CITY OF ALBUQUERQUE

**Re: KFC @ Eubank, 2201 Eubank NE,
Approval of Permanent Certificate of Occupancy (C.O.)
Engineer's Stamp dated 12/07/2007 (H20/D027)
Certification dated 10/03/07**

**Re: Kentucky Fried Chicken, 2201 Eubank Boulevard NE, Grading and
Drainage Plan
Engineer's Stamp dated 12-07-06 (H20-D27)**

Re: Kentucky Fried Chicken, 2201 Eubank Boulevard NE, Traffic Circulation Layout
Architect's Stamp dated 12-07-06 (H20-D27)

TCL-1

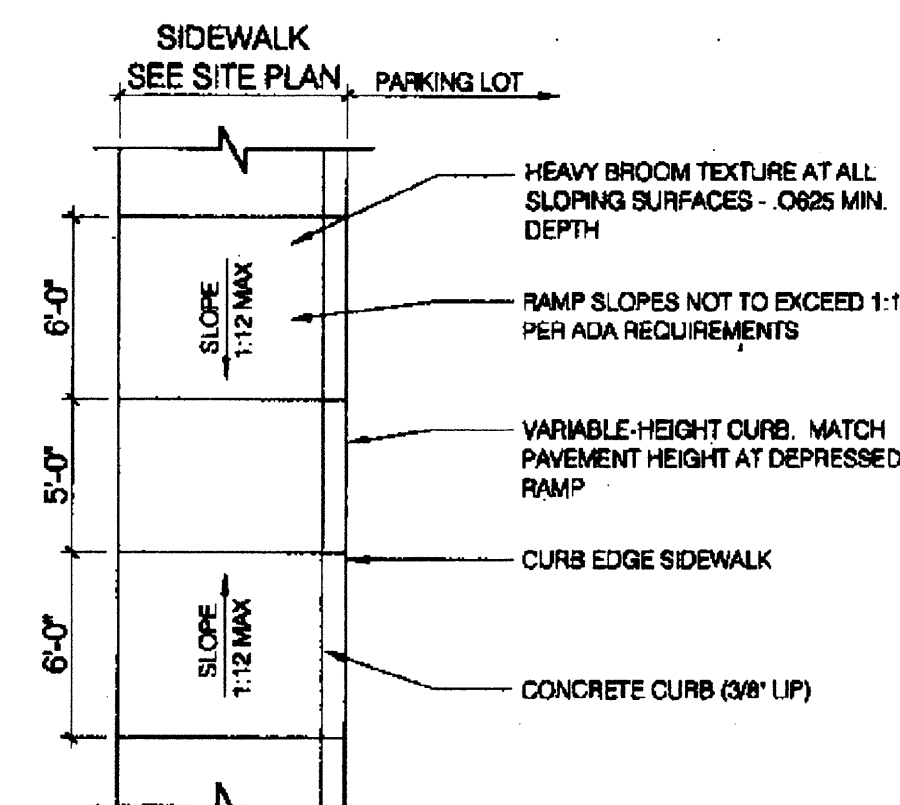
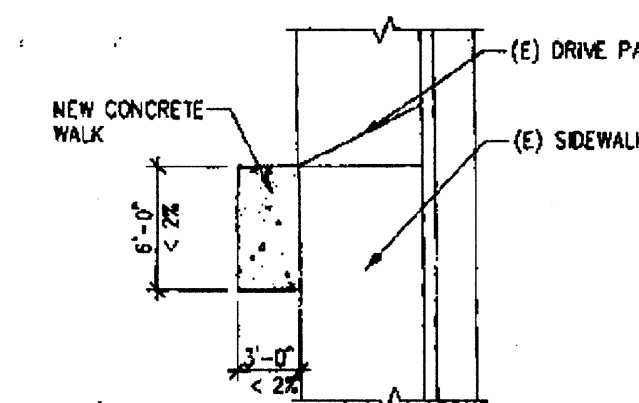
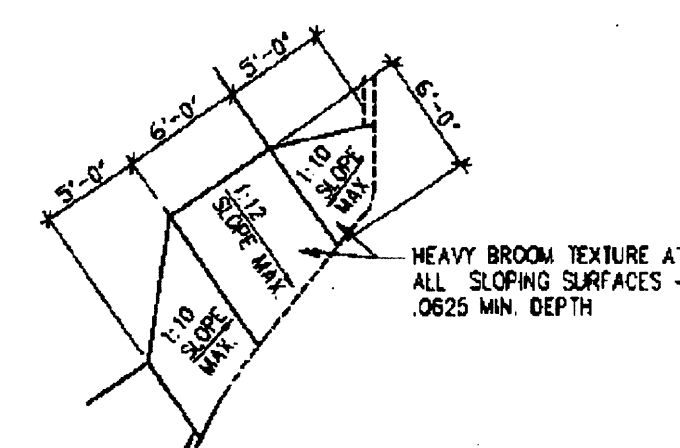
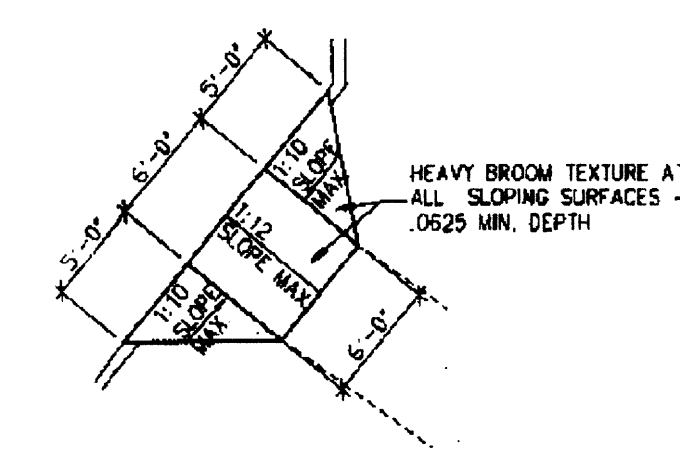
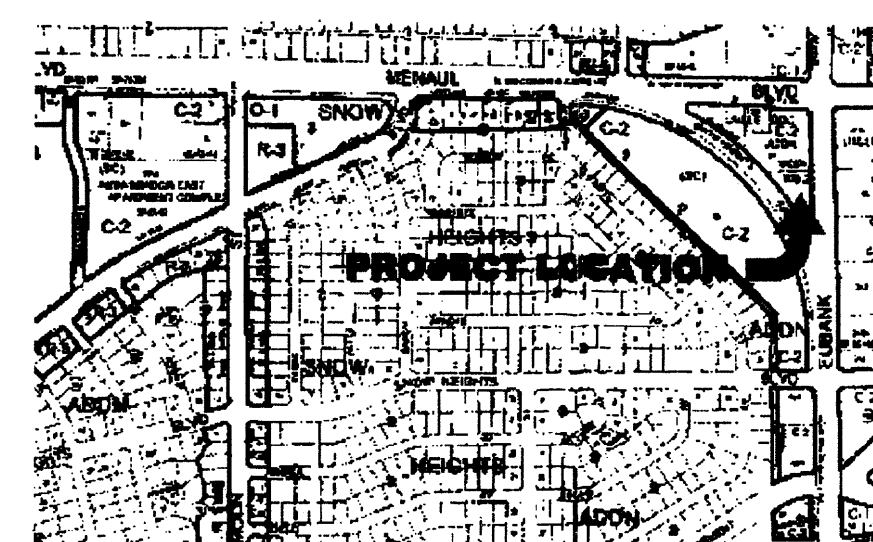
1. Define width of the existing sidewalk.
2. Please refer to all applicable city standards.
3. Per the *Development Process Manual*, Chapter 23, Section 7, Part E, Drive Through Facilities must meet the following criteria: "Minimum lane widths are 12 feet minimum with a 25 foot minimum radius (inside edge) for all turns. (A 15 foot radius can be used with an increase in lane width to 14 feet)."
4. Clarify existing versus proposed conditions. Will the existing layout be completely demolished?
5. Why is the sidewalk extension only proposed for one entrance?
